**KIRKLEES METROPOLITAN COUNCIL
INVESTMENT & REGENERATION SERVICE**

DELEGATED DECISION TO DETERMINE PLANNING APPLICATIONS

Reference No:	2023/62/91140/W
Site Address:	Park Views, 72, Beaumont Park Road, Beaumont Park, Huddersfield, HD4 5JH
Description:	Erection of outbuilding / pergola
Recommending Officer:	Laura Yeadon

DECISION – REFUSED

Drawing Title:
Proposed Site Plan

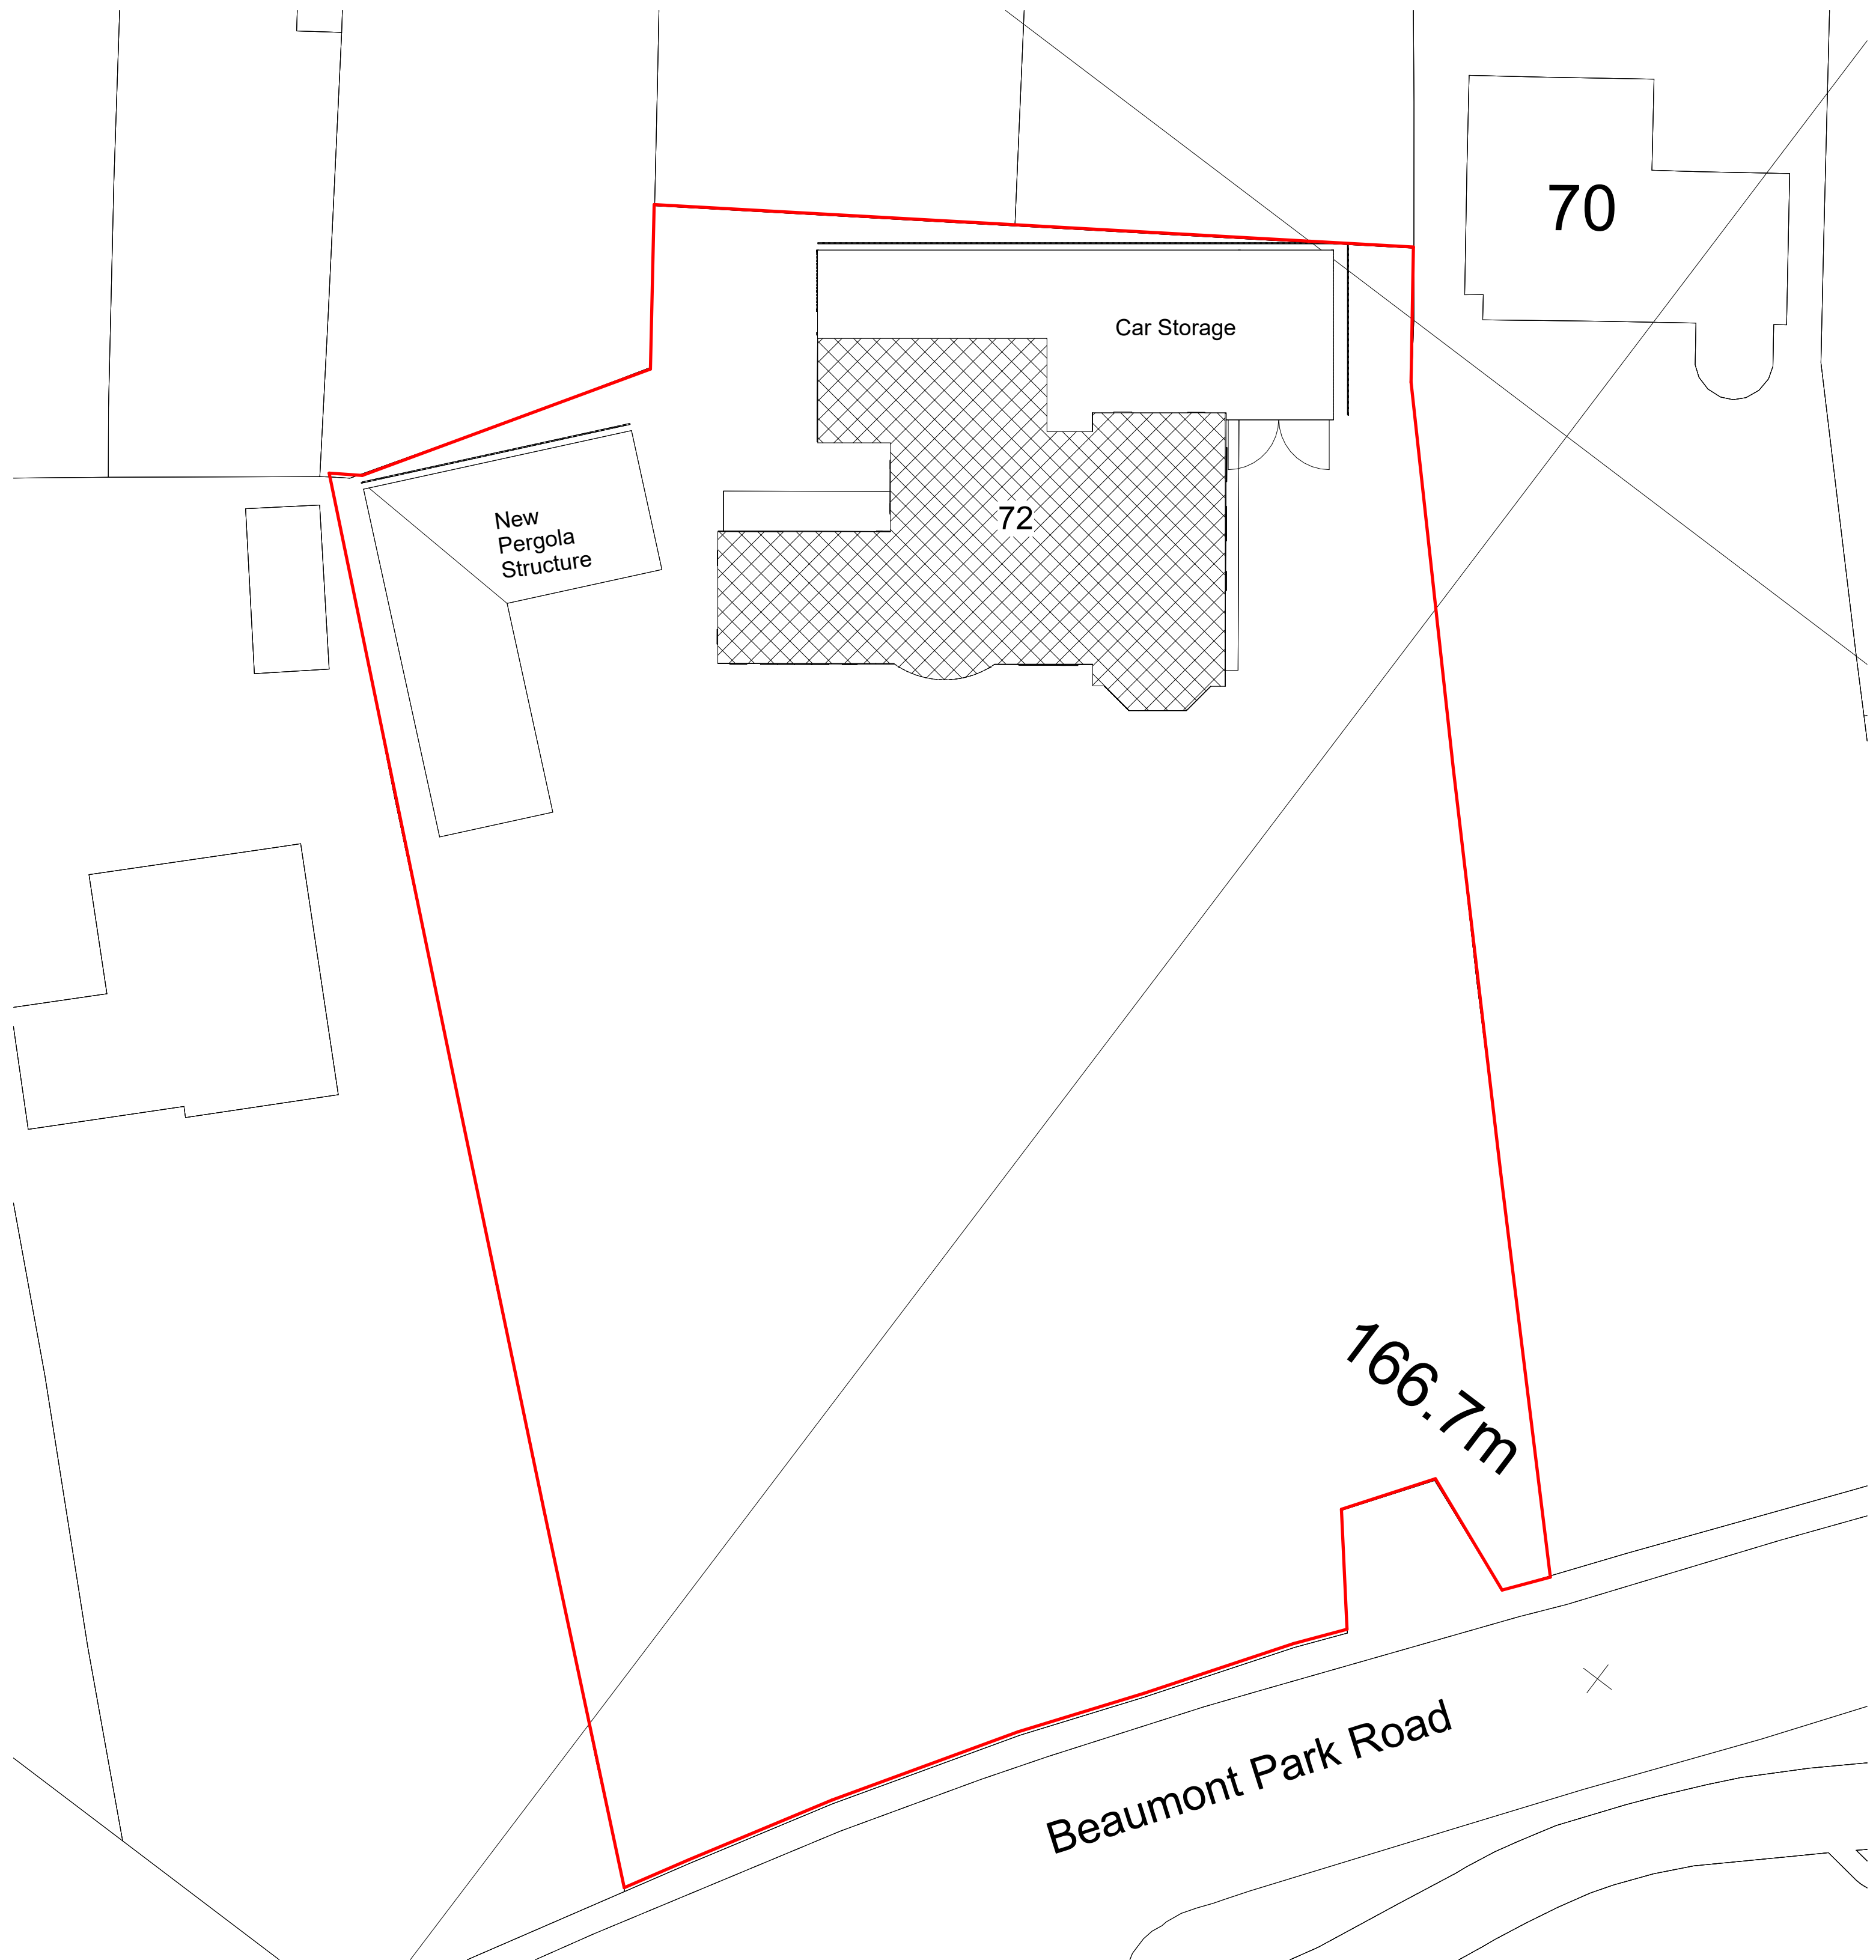
Key Design Principle 7 requires that useable areas of outdoor space are retained and in this instance due to the extent of curtilage and as demonstrated on the submitted site plan, the works are not considered to result in an overdevelopment of the site as a usable garden space remains. The development is therefore considered to comply with this principle.

Project Name 72 Beaumont Park Road, Beaumont Park, Huddersfield, HD4 5JH	
Drawing Title: Proposed Layout-Pergola	
Drawing Number: TR-A23-0103-005	Scale: 1 : 100@A1
Date: 11/04/23	Revision:
Drawn By: AM	Checked by: JA
Reason For Issue: Planning

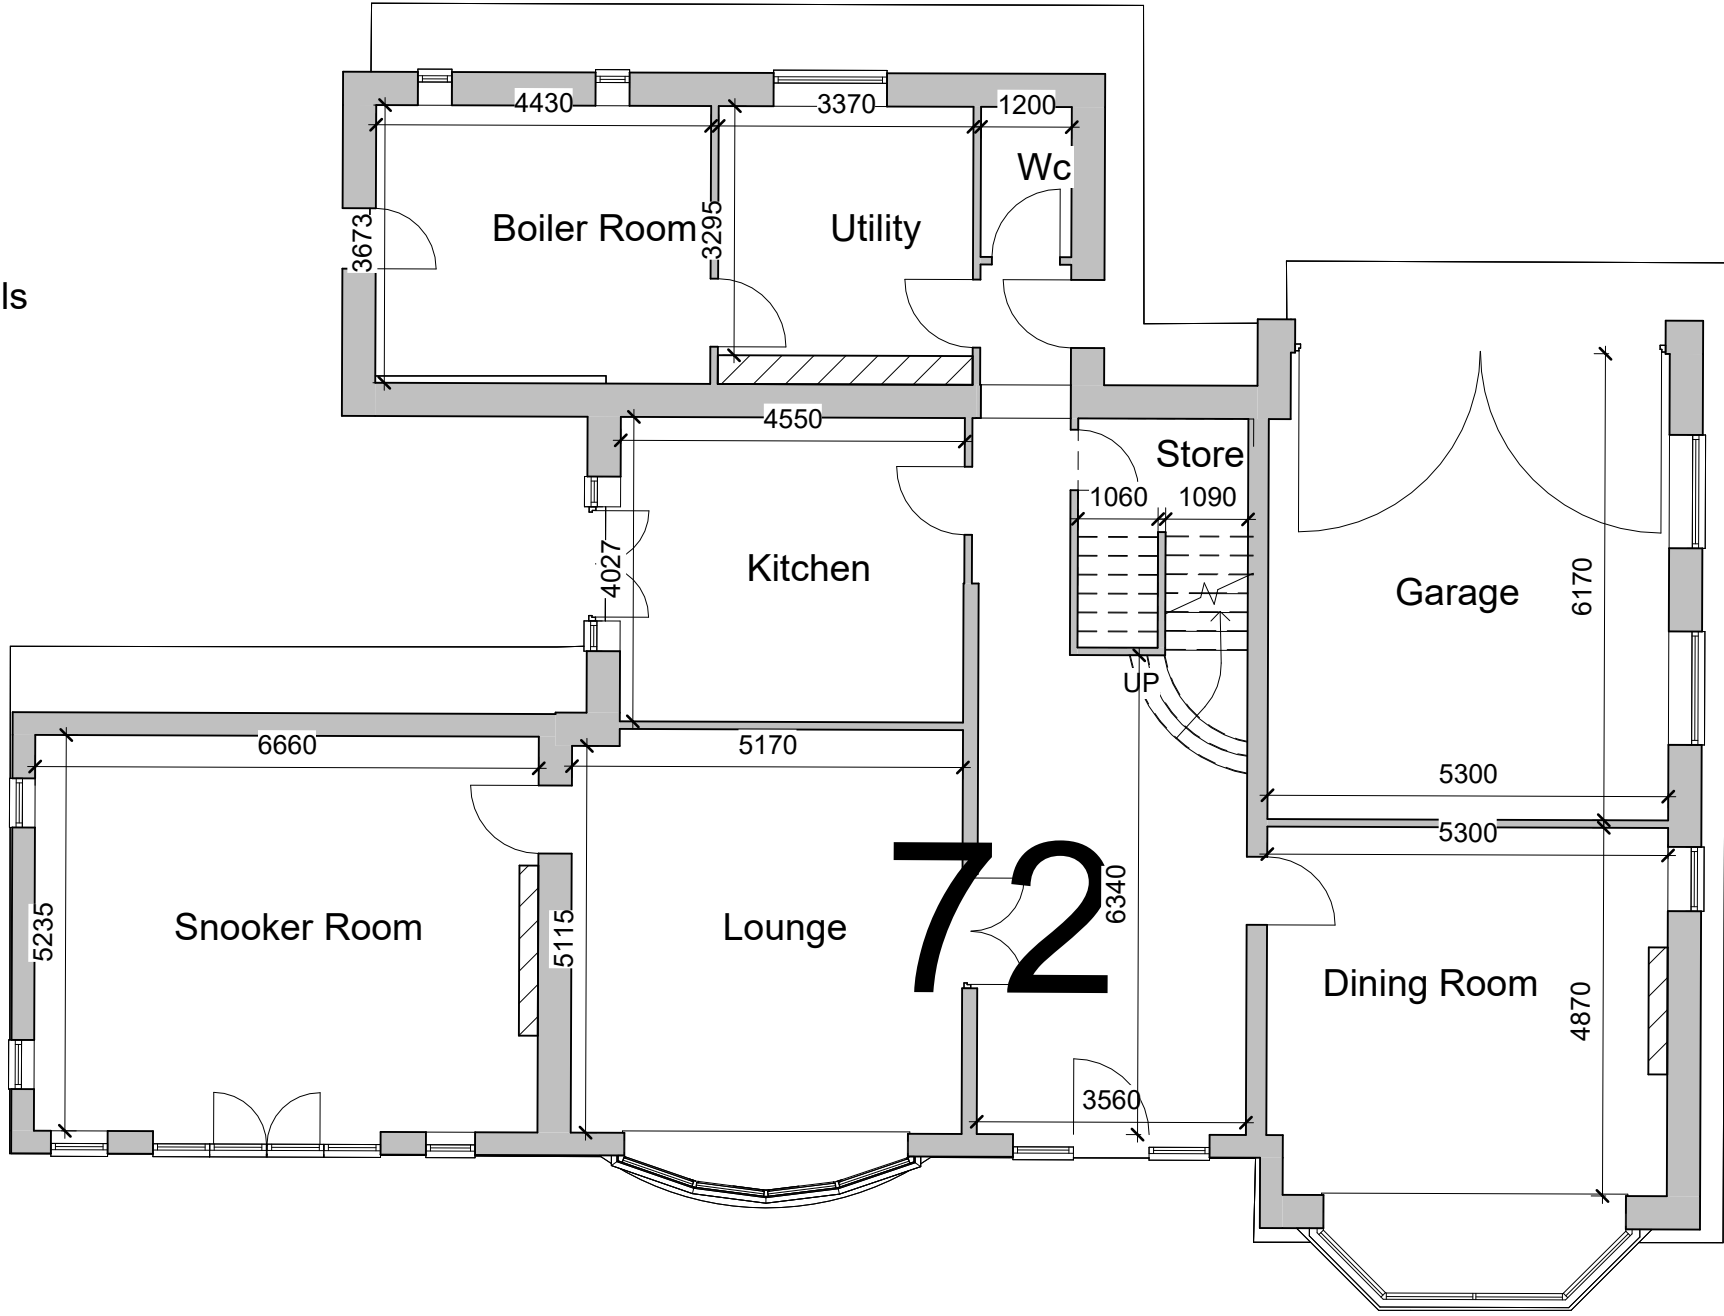
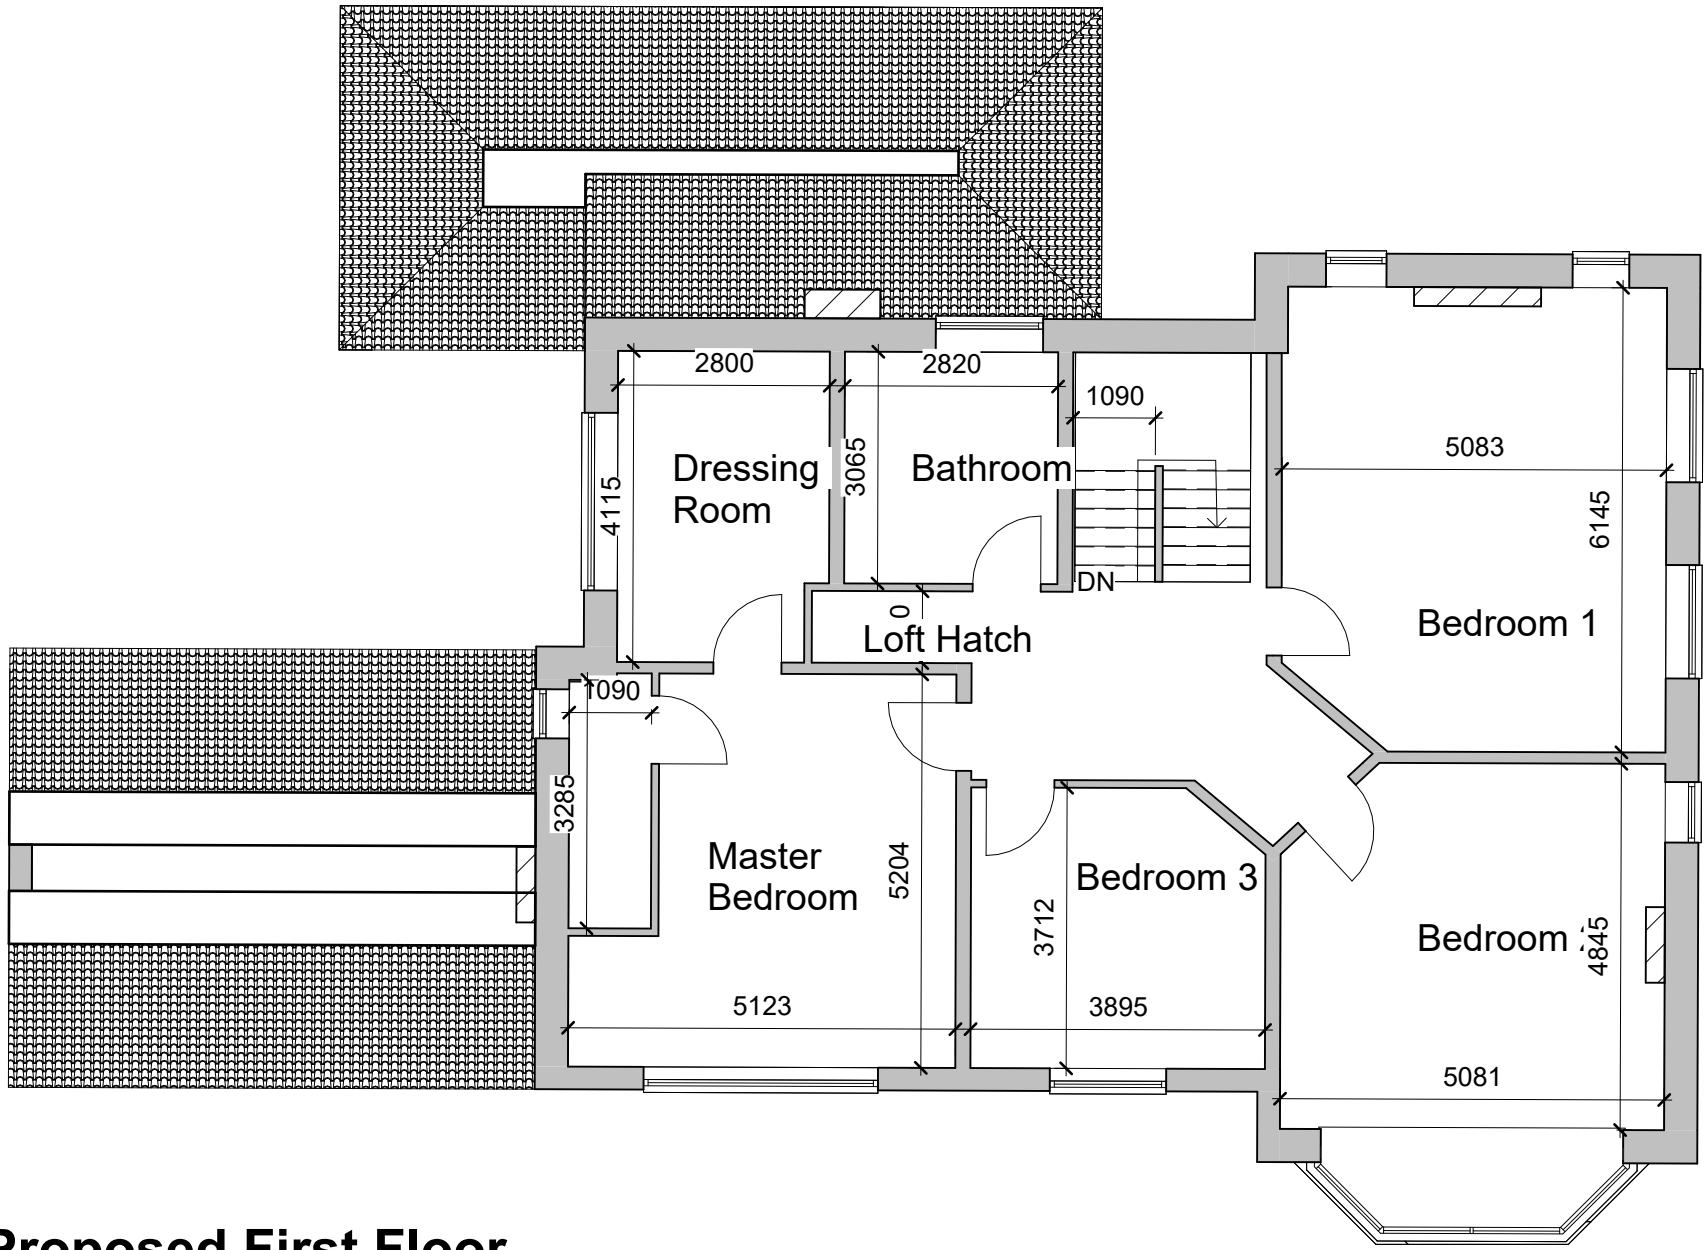
As previously assessed, the footprint of the building whilst having smaller footprint than the host property, is not considered to be sufficiently subservient to have a neutral impact on visual impact. The building line of the structure is not behind the original building line of the host property and whilst the structure

is screened from Beaumont Park Road, the wider street scene is characterised by dwellings set within modest curtilages, set back from the roadside with manicured front gardens which do not contain outbuildings. As such, this structure is considered to be out of character with the street scene. It is noted however that the building does allow for a sufficient level of garden space to remain.

In terms of the outbuilding/pergola, this is sited close to the boundary with the adjacent neighbour to the west. Due to the existing boundary screening with the neighbouring property being set forward of the structure and as the structure is single storey in height, it is not considered that this causes significant harm either (in terms of loss of outlook, loss of light and overshadowing).
